**Consultation Response from KC, Highways Development Management**
**2021/94280 land at Lady Ann Road, Soothill, Batley, WF17 0PY**
**Erection of 67 dwellings with associated works**
**Date Responded: 20/01/22**
**Responding Officer: A Darwin**
**Responding Ref: HDC 13-10NE/14**
**RECOMMENDATION: Further information required**

PROPOSED SITE PLAN

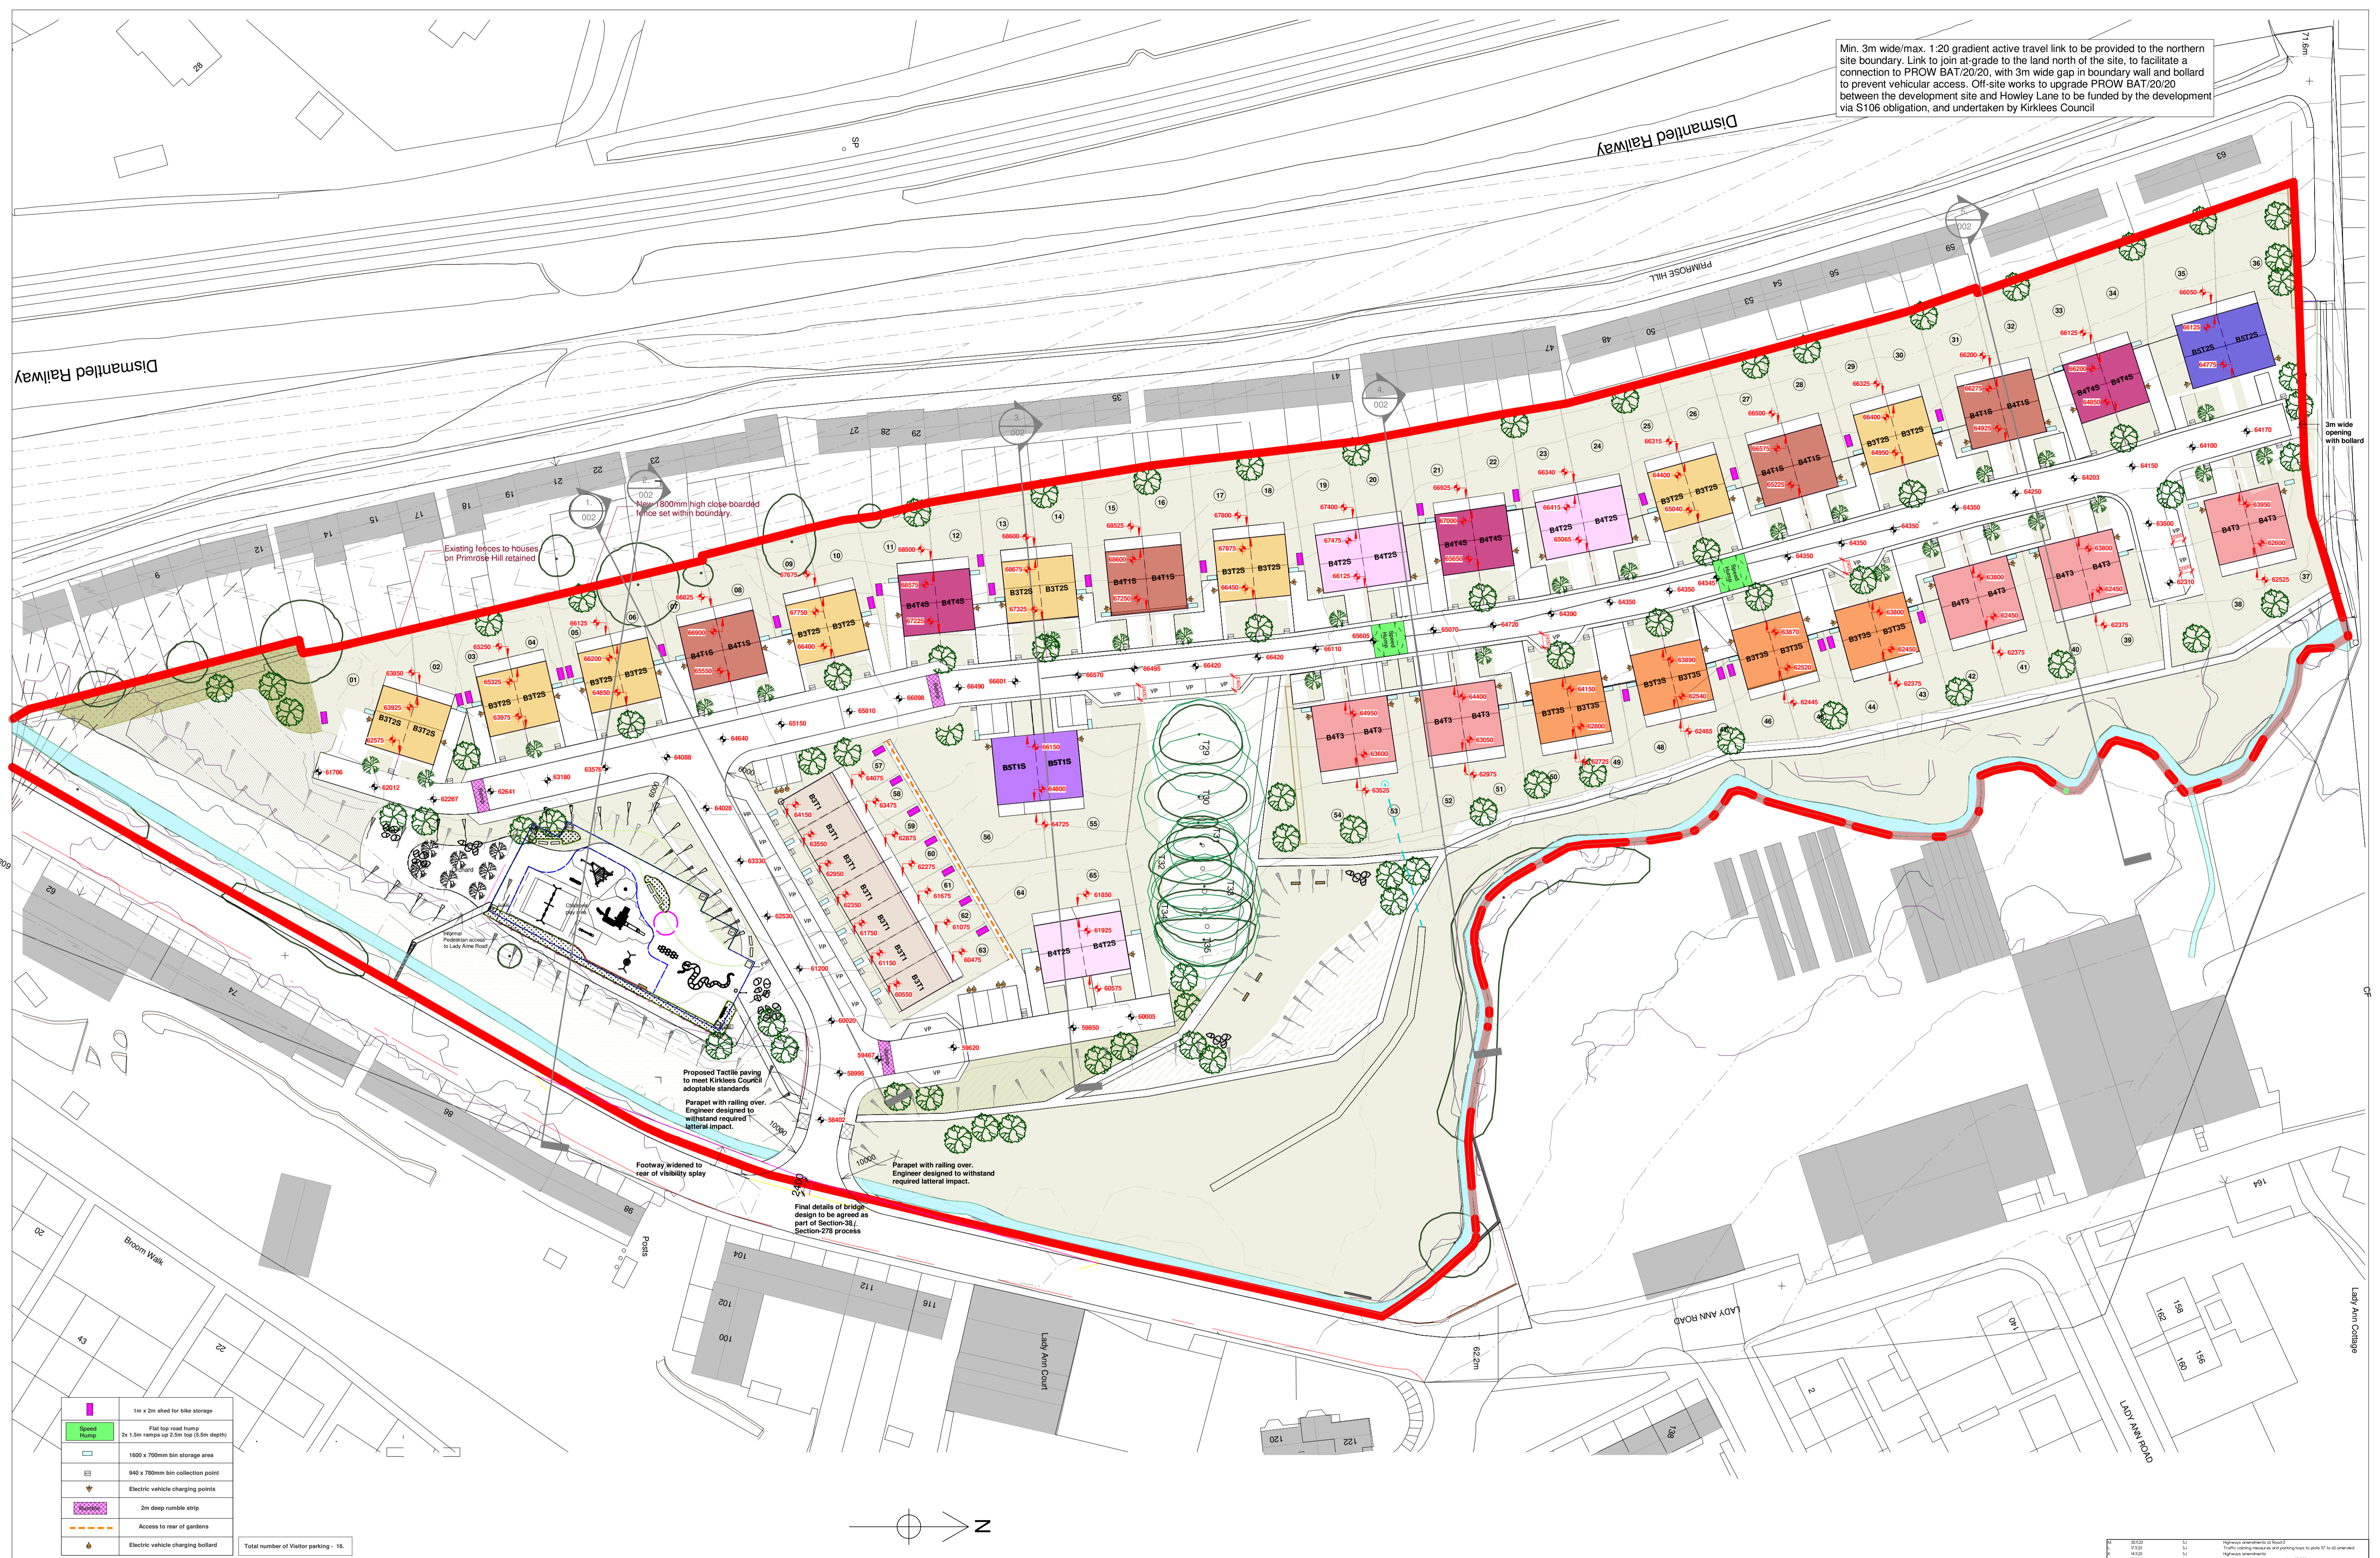
- Various amendments to the site layout and parking provision are required, with amended plans including construction details and Swept Path Analysis (SPA). Once agreed in principle, the site access and internal layout must be subject to a Stage 1 Road Safety Audit prior to determination;

At present, there is a private drive shown at the northern end of the site serving units 32-36. This also provides access to the pedestrian link to PROW BAT/20/20 that runs along the northern boundary of the site. It is requested that the private drive is amended to adopted highway to ensure that the link (min. 3m wide pedestrian/cycle link) connects to the adopted highway. This would also allow the 4 No. visitor parking bays shown on the private drive to be available for public use by all development users (this also applies to the private drive serving 70-71 and the associated visitor parking space, which should be replaced by adopted highway for this reason).

Whilst a pedestrian link has been shown from the site to Footpath BAT/20/20, it is recommended that this route is widened to a minimum of 3m and provided as an adopted Bridleway, to allow cyclists to safely use this route and access the railway crossing (where they will need to dismount to cross the railway). The new bridleway link will also need to connect to the adopted highway within the site. Therefore, as previously stated, it is requested that the private drive at the north of the site is replaced by an adopted highway, or other alternative arrangements proposed to meet this requirement.

The site includes a single point of access on the west side of Lady Ann Road, approximately 200m north of the Primrose Hill junction. The access is proposed to be 5.5m wide, with 2m footways on both sides, and 2.4x43m visibility splays. However, no detailed plans of the site access have been provided, including details of the proposed junction radii, the protected visibility splays, fence treatments or bridge crossing of the beck. Therefore, it is not possible to determine whether the access arrangements are acceptable.

Only limited Swept Path Analysis (SPA) information has been provided at the site access. However, from the information provided, it is clear that the Councils Design Refuse vehicle will not be able to safely enter/exit the site when existing car parking is taking into consideration, which currently takes place on the opposite side of Lady Ann Road to the site access. To address this issue, increased junction radii appears to be necessary.

- The bend adjacent to No. 62 has a centre line radius below 20m, which is below Council standards and will not allow a refuse vehicle to safely pass an oncoming or parked vehicle. The associated visibility envelope at the bend is also inadequate (min. 25m required) and appears to be blocked by a proposed hedge. All junction and forward visibility enveloped must be located within the adopted highway and protected from obstruction. The bend should be amended to address these issues and may require localised carriageway widening.

- The bends adjacent to No. 63-65 also appear to have inadequate centreline radii and forward visibility, and should also be amended.
- Adequate visitor parking must be incorporated into the layout, with a minimum provision of 1 space per 4 units. Ideally this should be in the form of laybys that are parallel to the carriageway. At present on 16 spaces are proposed within the layout, with 5 of these spaces being on private drives, which will be inaccessible to all users. Therefore, additional visitor parking is required, particularly within the vicinity of the play area, where on-street parking would block forward visibility and restrict access by the Councils refuse vehicle. All visitor parking spaces should be provided in parallel laybys, which are a minimum of 6m long by 2.4m deep (6x2m is acceptable when adjacent to a footway).

- The shared surface road serving No. 7-61 is very straight. As such it is unlikely that the required 15mph design speed would be achieved, which may create safety problems for pedestrians and cyclists. As such, the layout should be amended to ensure that a suitable design speed is achieved and that safe access for pedestrians and cyclists is provided. At present, no gradient information has been provided. However, it is envisaged that the access road will be relatively steep, which would further contribute to these safety concerns.

- As previously stated, a minimum 3m wide combined pedestrian / cycle link should be provided at the north end of the site that connects to Footpath BAT/20/20. This link must connect to the adopted highway within the site.

- Visibility splays of 2.4x 25m are required at internal junctions and forward visibility of 25m is required on bends. These splays/sightlines should be demonstrated on a plan for review. All visibility splays/sightlines must be contained within the adopted highway.

- All junction radii should to be a minimum of 6m (10m radii are likely to be required at the site access, due to presence of on-street parking) to assist with refuse swept path movements. This also applied at proposed turning heads.

- All shared surface roads should be a minimum of 5.5m wide with 0.6m wide margins. Shared spaces should have a gradient not steeper than 1:20. If this cannot be achieved then a separate footway along the shared space should be provided too;

- Swept Path Analysis (SPA) is required to demonstrate that the Kirklees Design Refuse Vehicle can pass an oncoming vehicle or parked vehicle, and turn within all turning heads unobstructed. Revised SPA should be provided of the entire site layout at an increased scale, which must be in accordance with the vehicle parameters set out in Table 1 of the S38 design guide entitled 'Emergency Access, Waste Management, Servicing and Deliveries – April 2020 (version 1)'. From a review of the SPA currently provided, it appears that stationary steering has been used, which is not in accordance with the above requirements and is not acceptable.

It is noted that some of the single width drives are only 3m wide, without any additional width for passing pedestrians, or to allow disabled users to access a parked vehicle. Therefore, single drives should be widened to a minimum of 3.6m.
